**R/238/14/PL – 1 No. dwelling and associated landscape works. Resubmission.
EP/58/14/PL – Land west of Paddock Place (Little Fosters), Tamarisk Way, Rustington**

**Public Consultation for Proposed New Dwelling: Land West
of Paddock Place, 36 Tamarisk Way, East Preston,
Littlehampton, West Sussex BN16 2TE**

**PROPOSED SITE PLAN.
FEBRUARY 2013
1:500 @ A3.
4112-03^A**

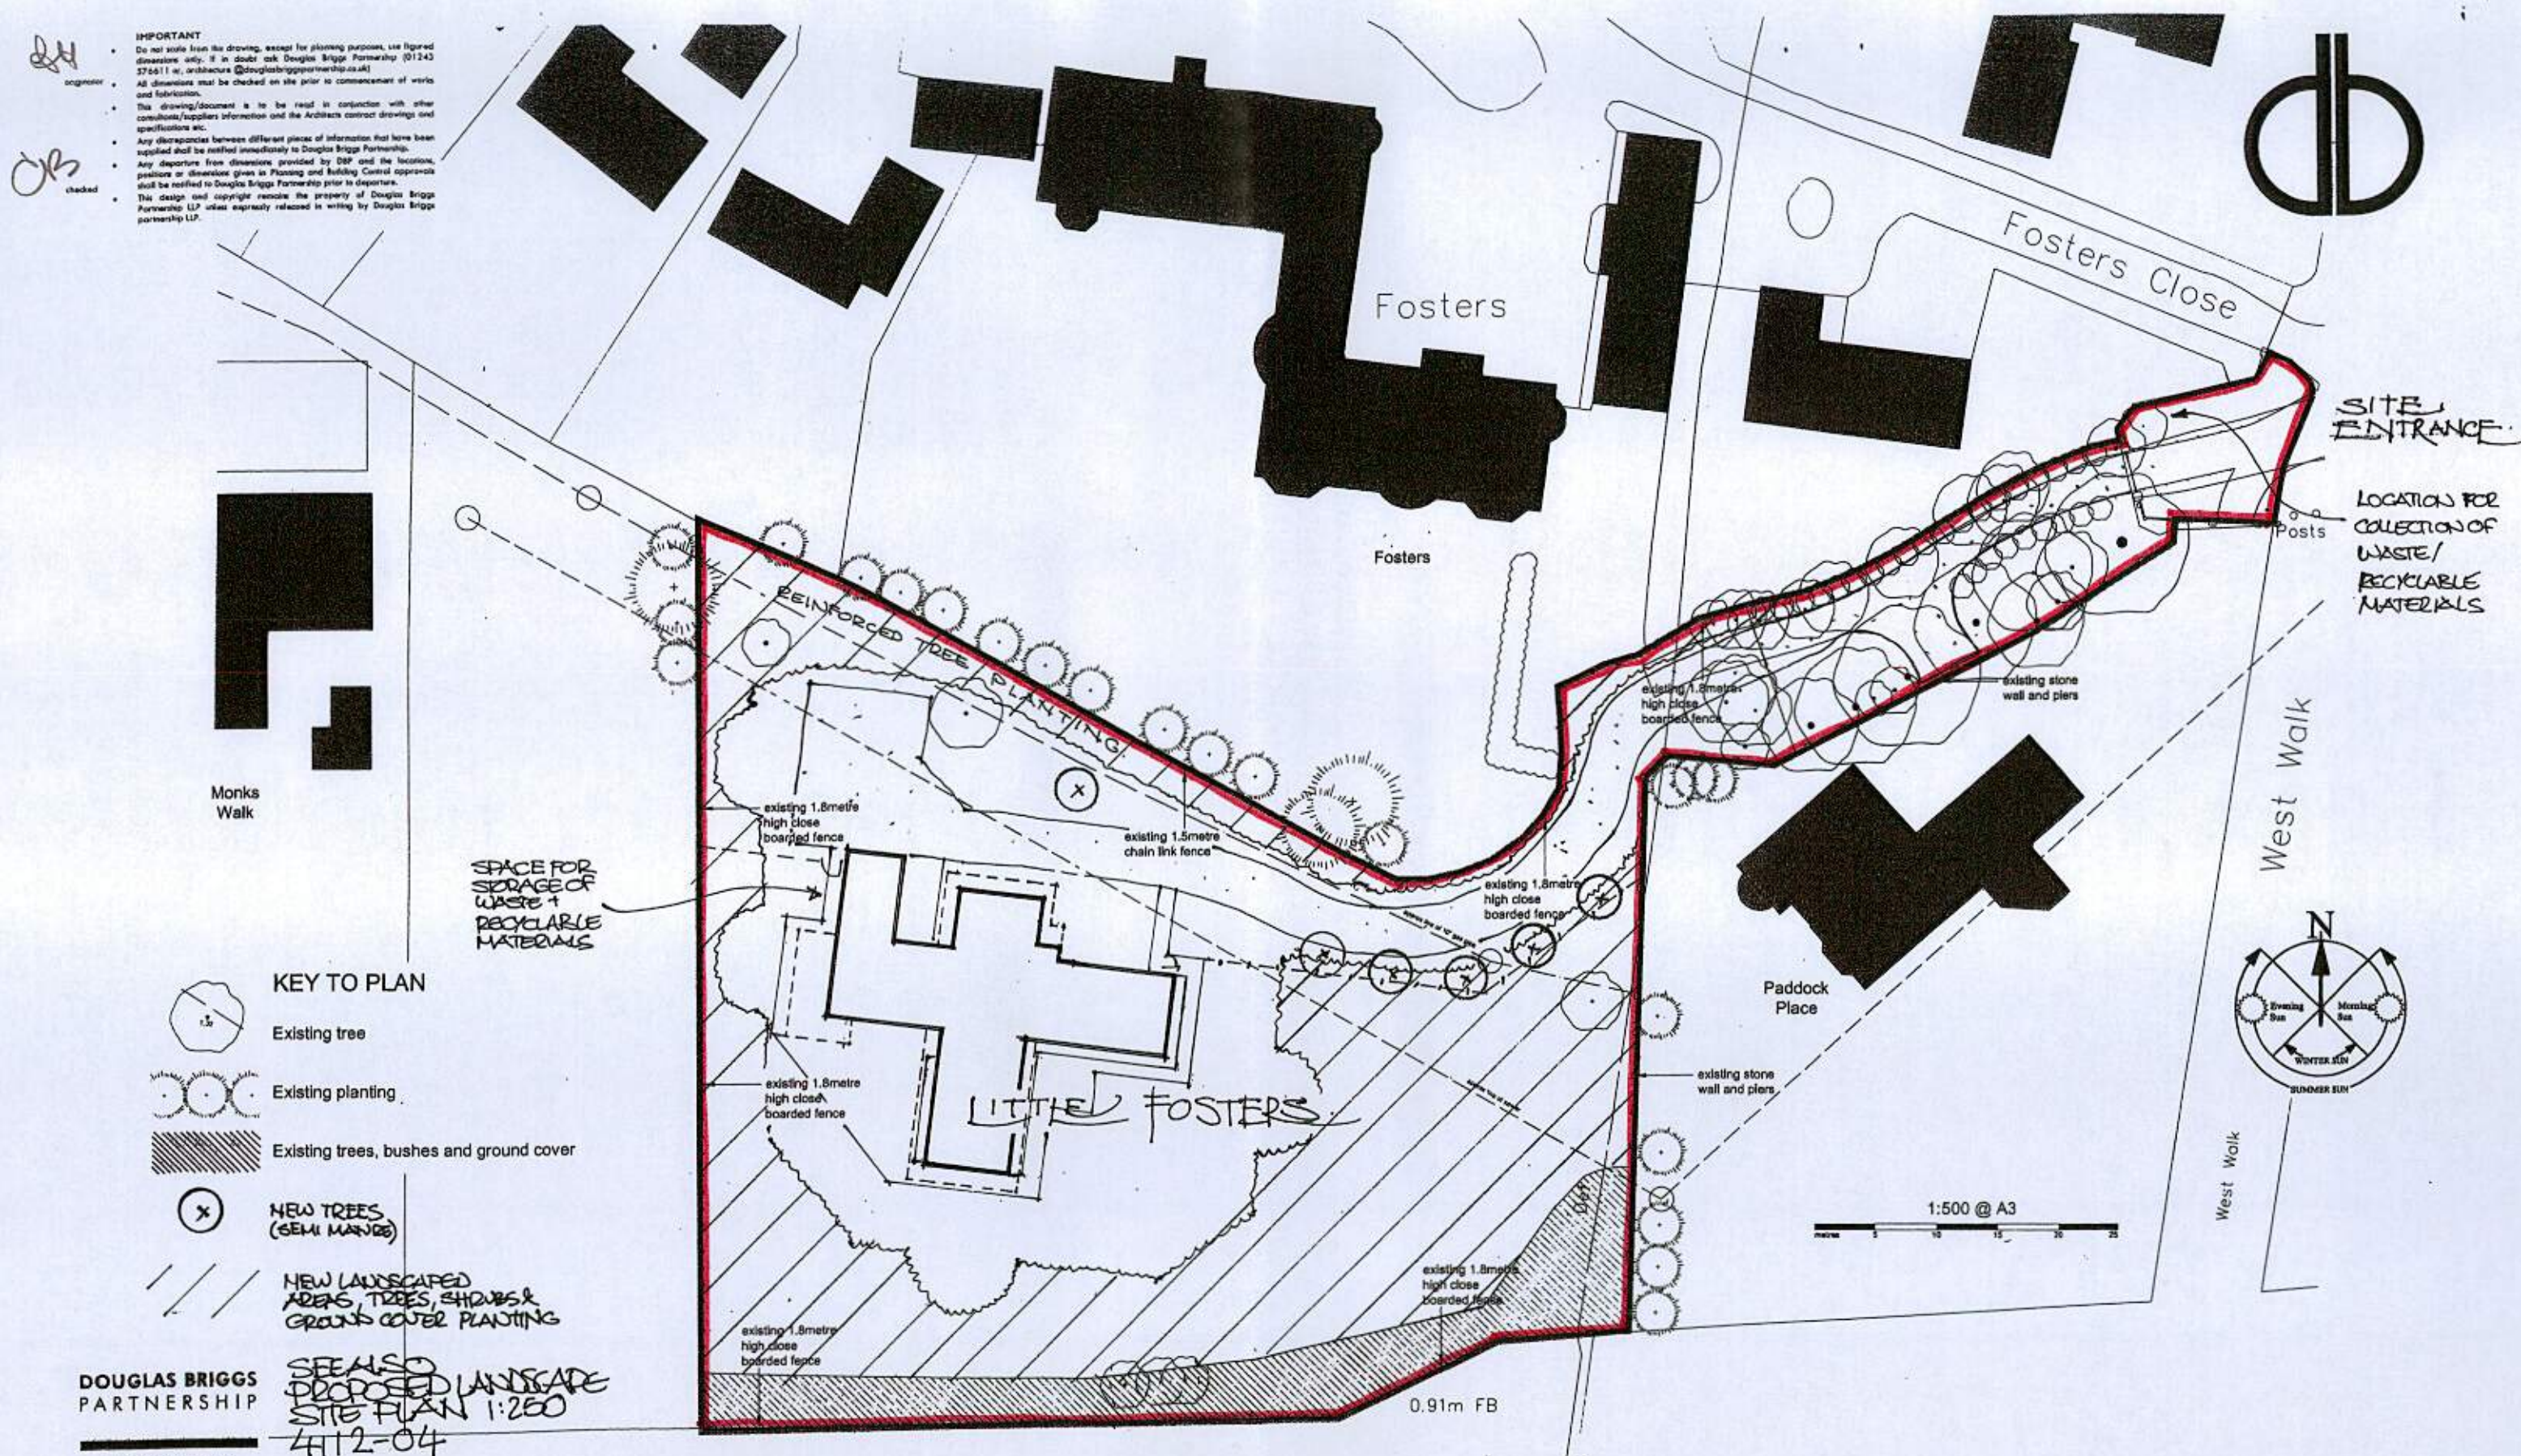
**On the deeds of our property, Craven House – 2 Fosters Close,
a ditch is outlined, running immediately behind the southern border.
i.e.: Extreme north on the land of the propose new dwelling.**

**This ditch runs westward to join an existing ditch, which runs the
entire length of Angmering Lane. On purchasing our property, we
were advised by our Solicitors, to the effect that the ditch
immediately behind our southern border should never be filled in.**

**We would suggest that the existing ditch is left in place and all tree
planting be immediately south of this ditch. We would very much
appreciate the existing hawthorn and bushes being left in place.**
